Project# 1005357

TO: DRB Chair
FROM: Carmen Marrone, Senior Planner
RE: **Project #1005357, Oxbow Town Center**

Project# 1005357
07DRB-70392 MAJOR - PRELIMINARY PLAT APPROVAL
07DRB-70395 EPC/ SDP FOR SUBDIVISION

SURV-TEK INC agent(s) for OXBOW TOWN CENTER, LLC request(s) the above action(s) for all or a portion of Tract(s) X-1-A2 & X-2-A UNIVERSITY OF ALBUQUERQUE URBAN, **UNIVERSITY OF ALBUQUERQUE URBAN CENTER to be known as OXBOW TOWN CENTER**, zoned SU-3 (R-2,C-2, 0-1), located on ST JOSEPH'S DRIVE NW BETWEEN COORS BLVD NW AND ATRISCO DRIVE NW containing approximately 47.72 acre(s). (G-11)

PLAT OF
OXBOW TOWN CENTER
(BEING A REPLAT OF TRACTS X-1-A2 AND X-2-A,
UNIVERSITY OF ALBUQUERQUE URBAN CENTER)
WITHIN
THE TOWN OF ALBUQUERQUE GRANT
IN
PROJECTED SECTION 2, TOWNSHIP 10 NORTH, RANGE 2 EAST
NEW MEXICO PRINCIPAL MERIDIAN
CITY OF ALBUQUERQUE
BERNALILLO COUNTY, NEW MEXICO
NOVEMBER, 2007

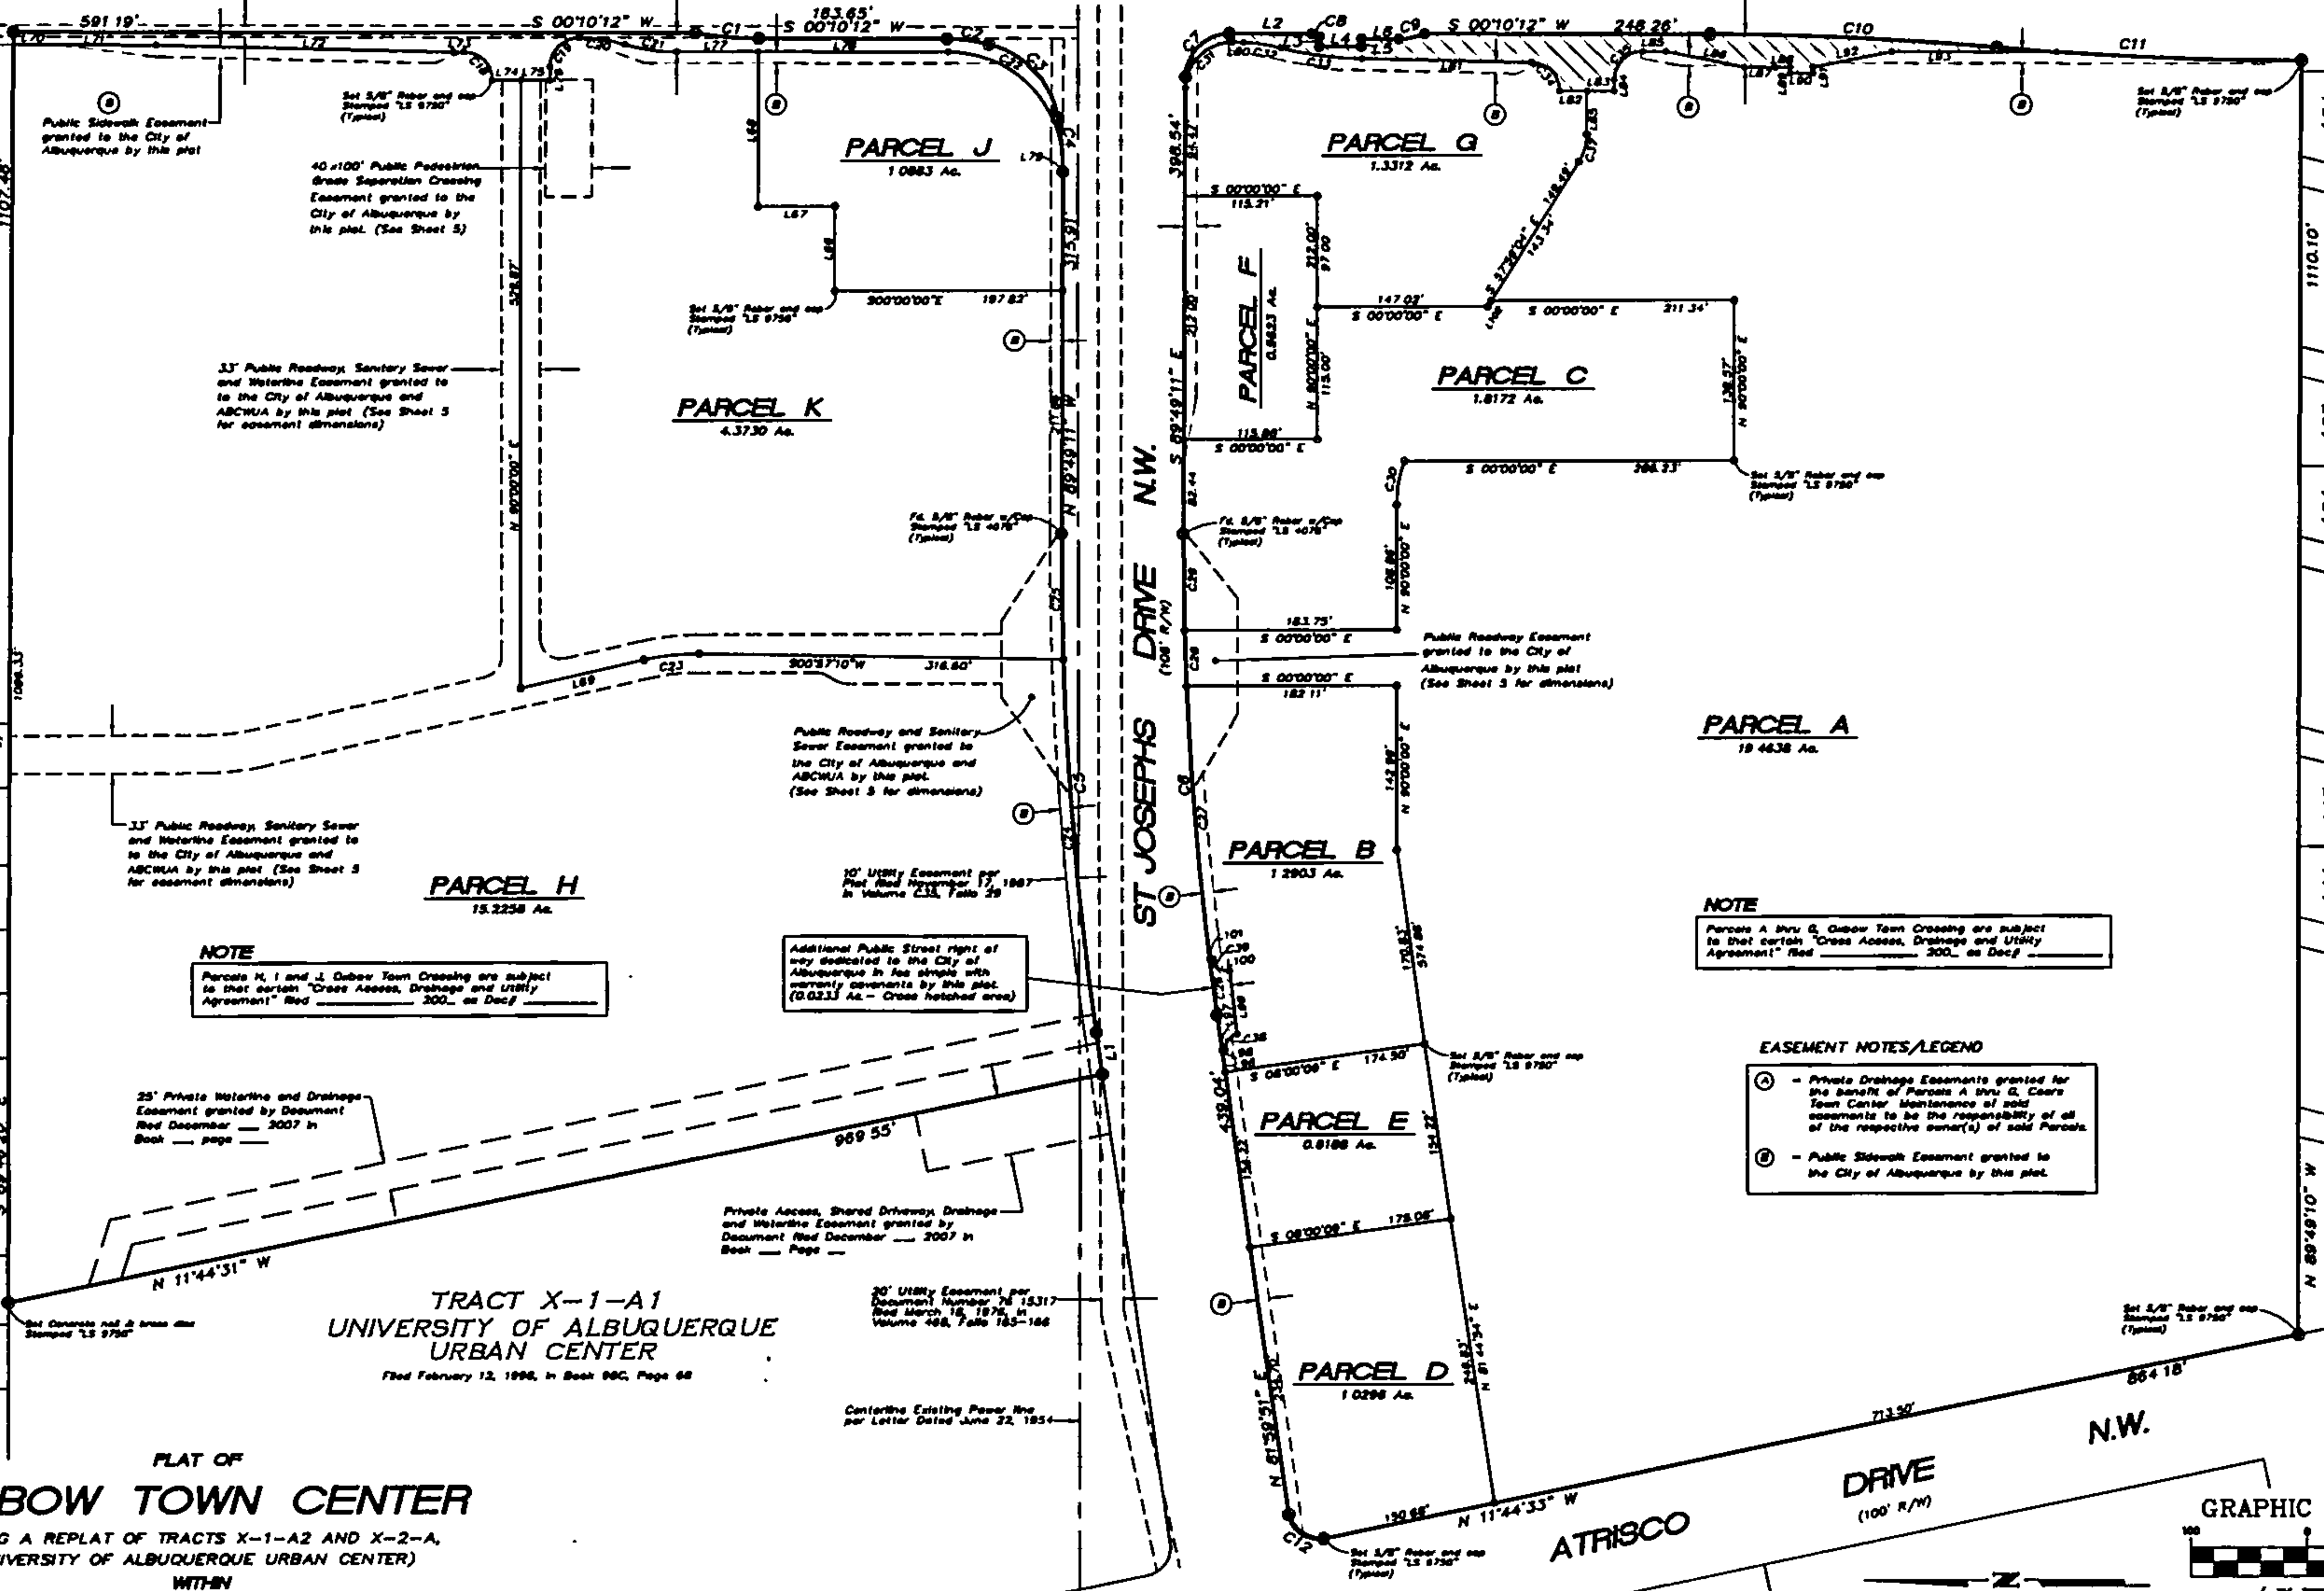
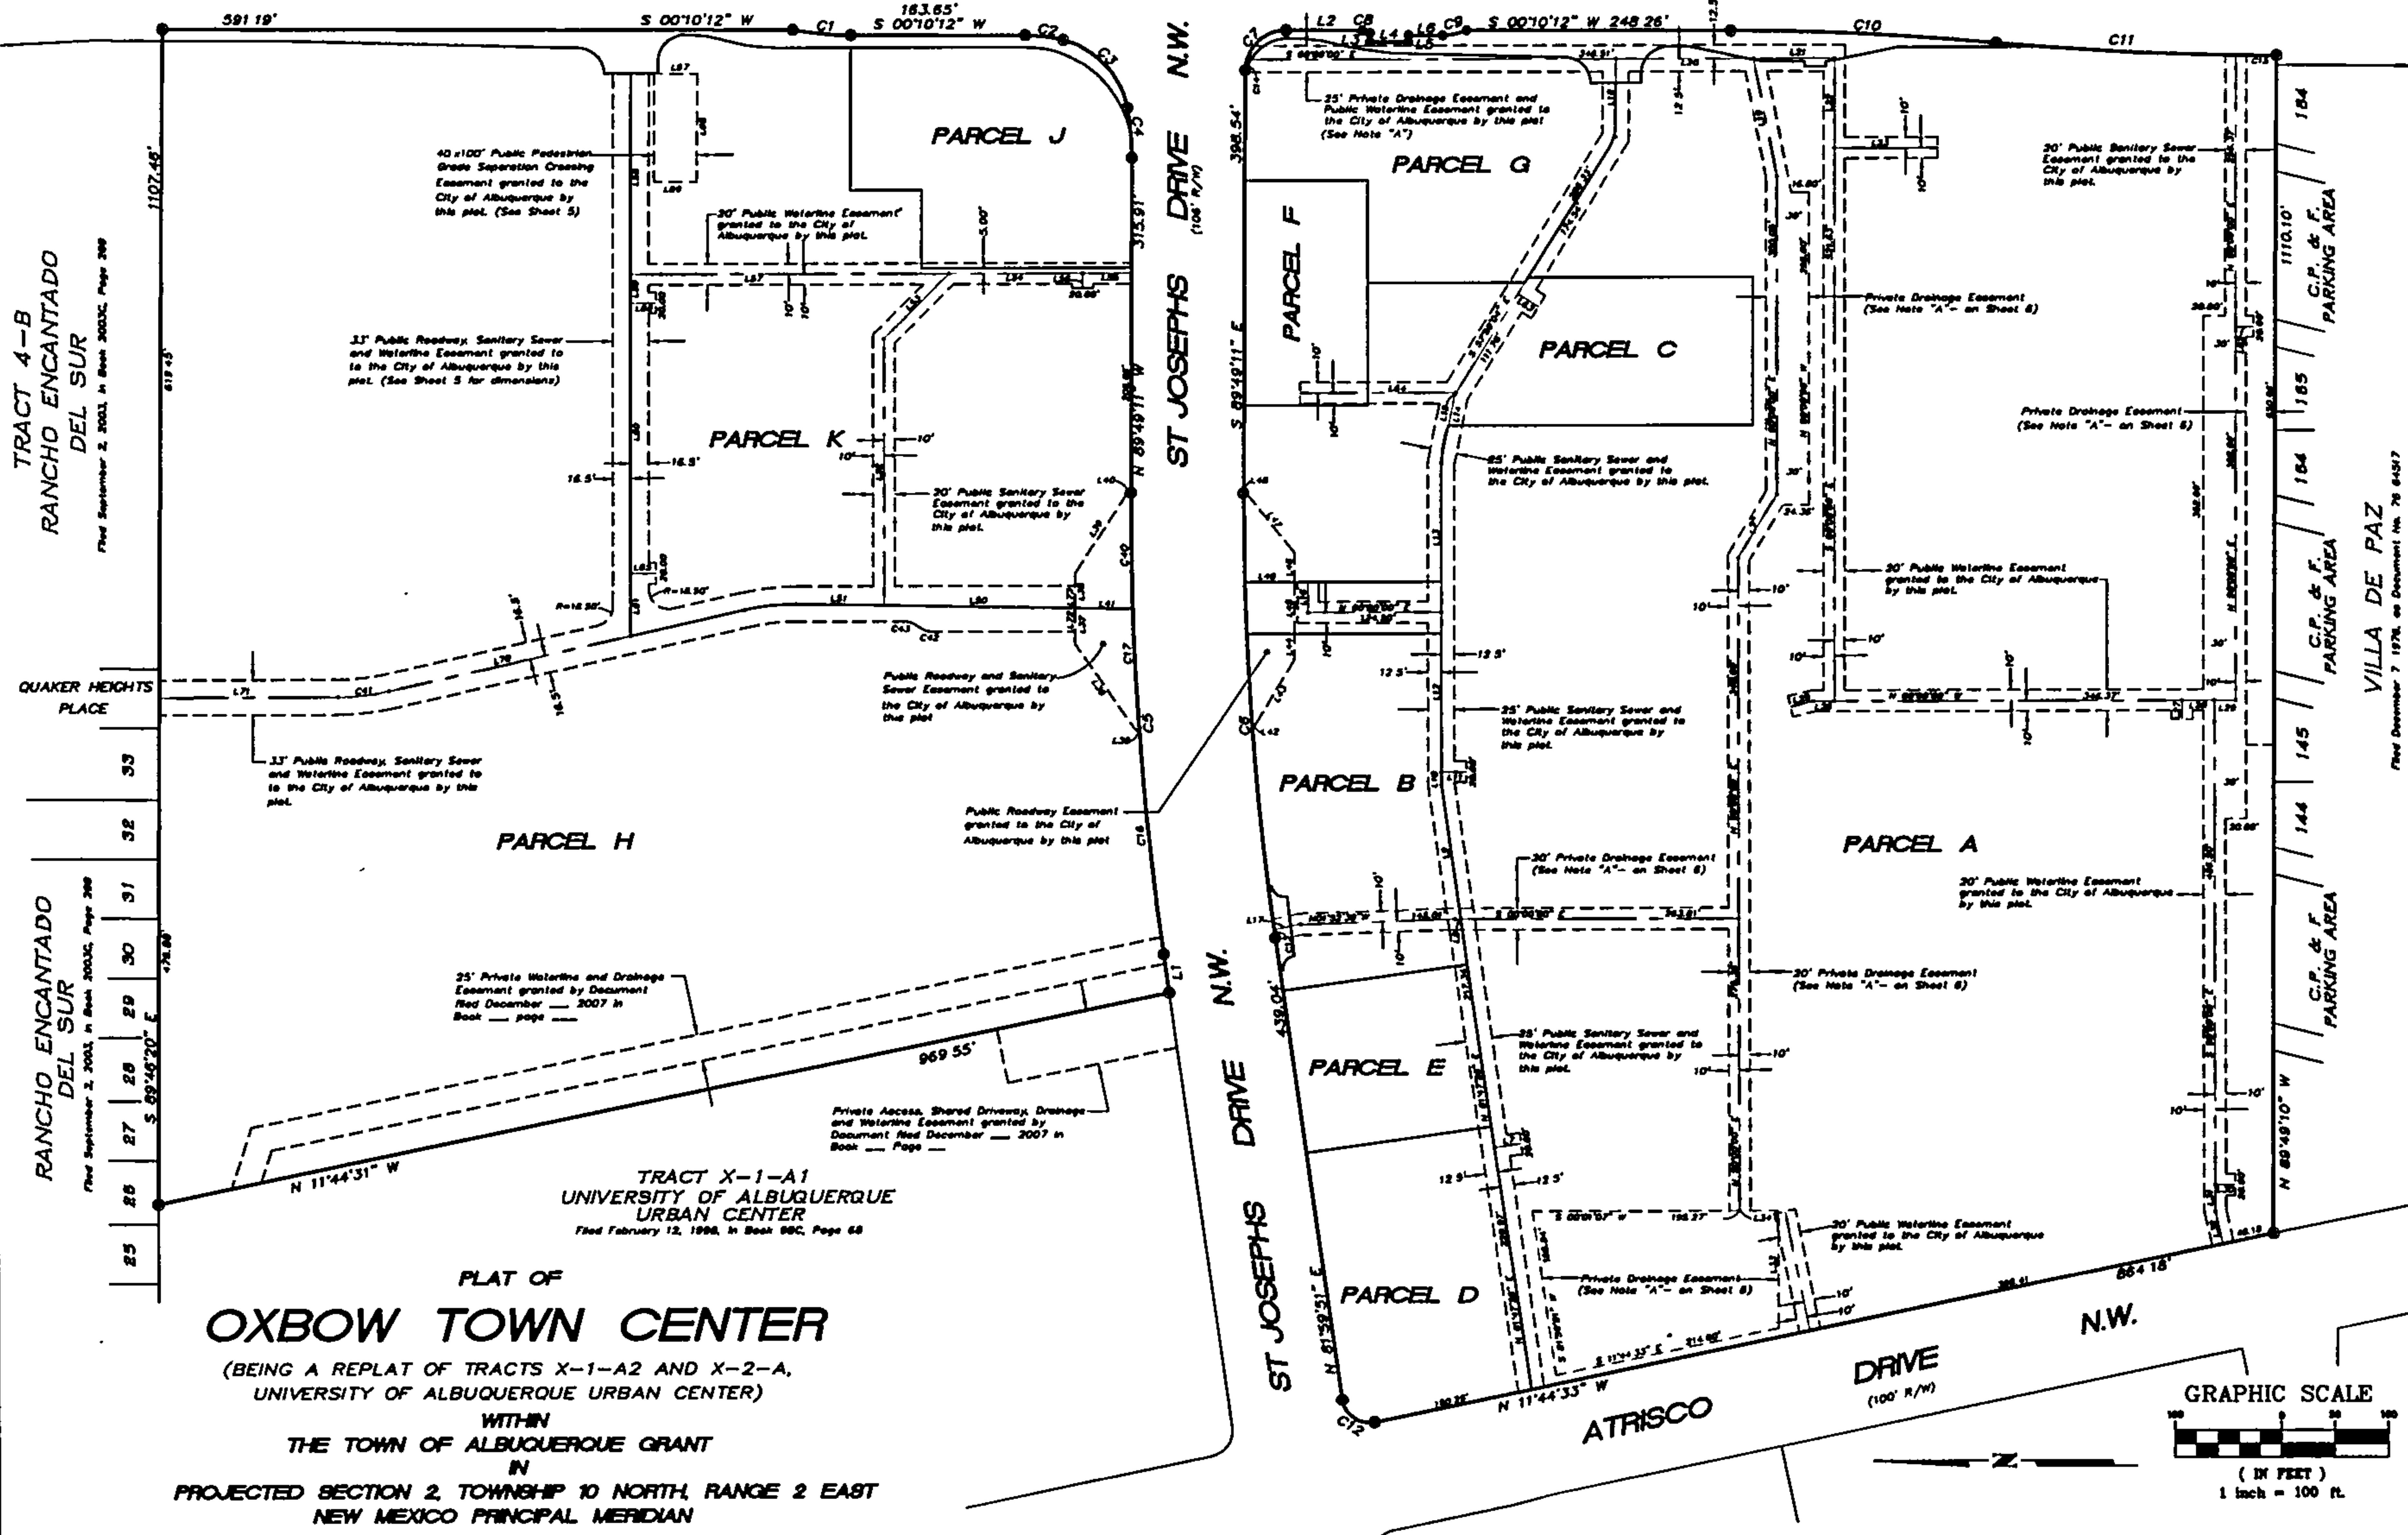
Parcels A, K, and H contain public roadway easements; explain why these easements should be public

Public Pedestrian Grade Separation Crossing easement only 20 feet wide? Provide more information

Per the Development Process Manual, Table 23.3.3, the right of way at the intersection of a minor arterial and a collector roadway requires a radius of 30 feet (see curve C12)
